Solid Ground Engineering

RE: Serenity Trails PA24-001, Technical Review #1

Project: Serenity Trails

PP-01
3 OF 8

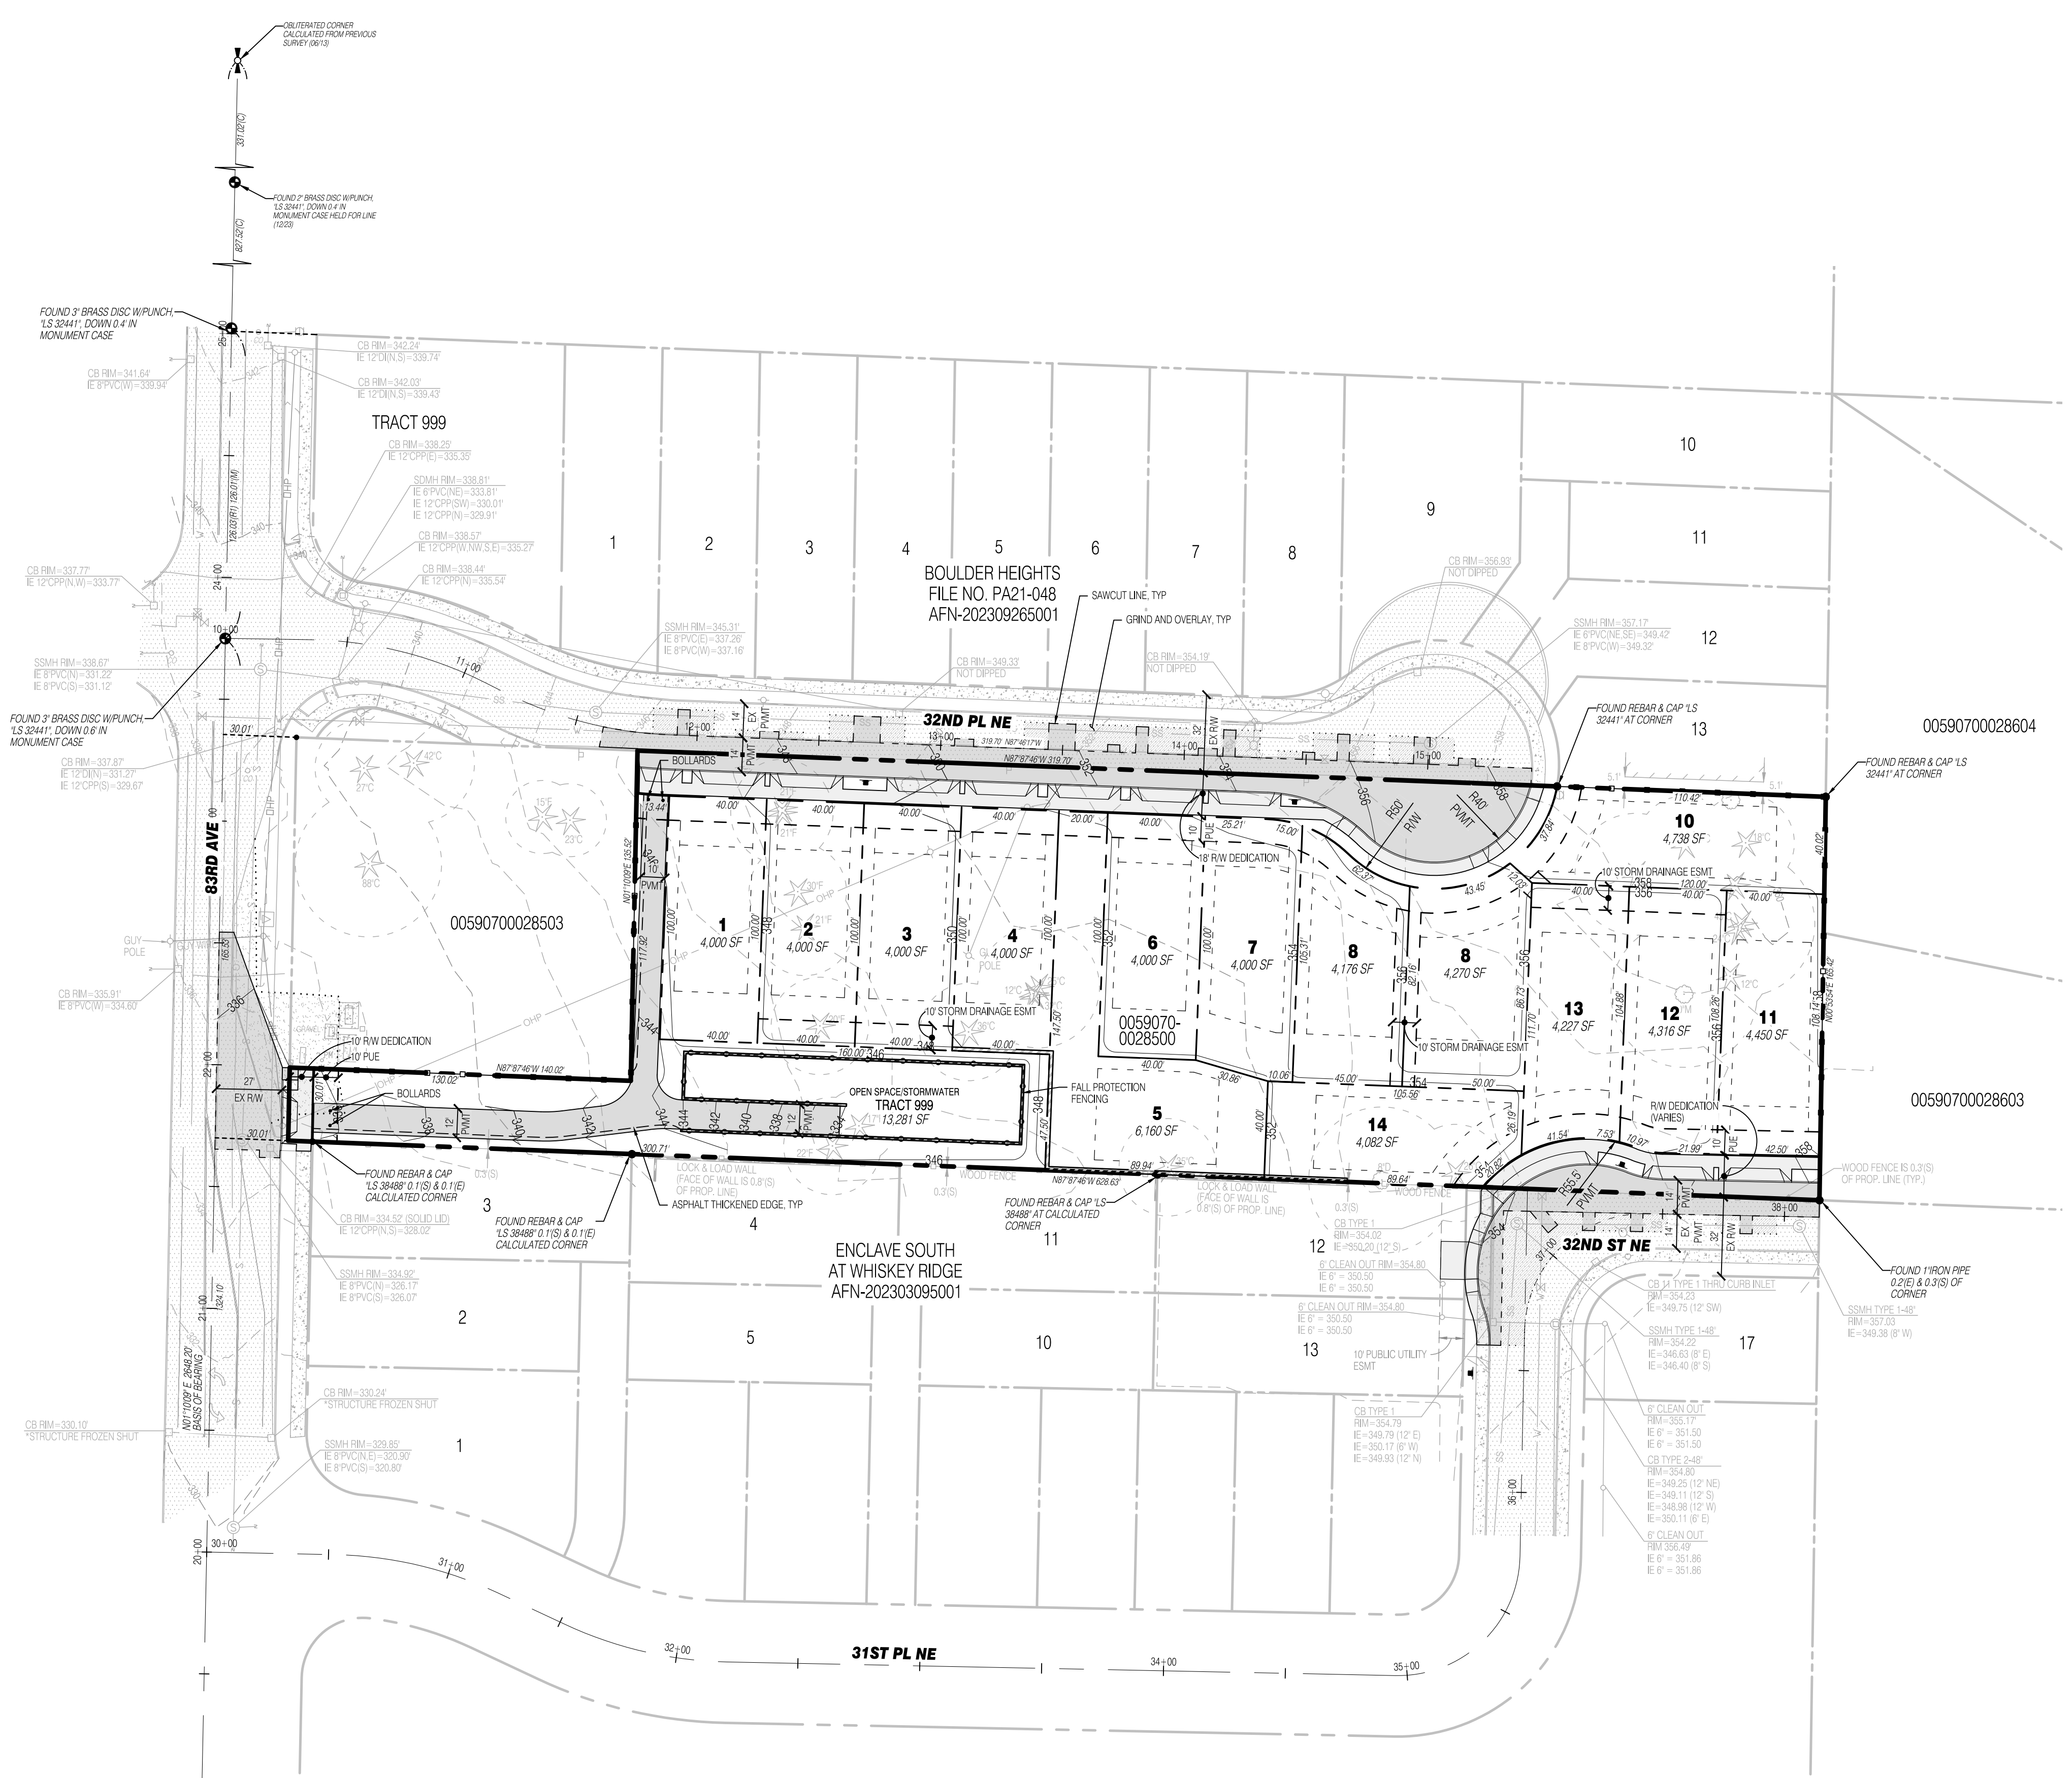
3. Undergrounding of existing overhead utilities along the frontage of 83rd Ave NE shall be required.

1. Lots 11, 12, 13, and 14 will require 13D fire sprinklers due to single-point access from 83rd Ave NE per MMC 9.04.503.1.5 Exception 1.

2. Lot 5 will also require a 13D fire sprinkler due to distance from ROW per EDDS 2-060.D.12.

Response: A note has been added to sheet PP-01 indicating underground of existing utilities along 83rd Ave NE.

Response: Noted. A note calling out these lots for sprinklers has been added to sheet WA-01 of the civil plans that will be submitted at a later time. It has also been added to sheet PP-01.

Response: Noted. A note calling out this lot for sprinklers has been added to sheet WA-01 of the civil plans that will be submitted at a later time. It has also been added to sheet PP-01.
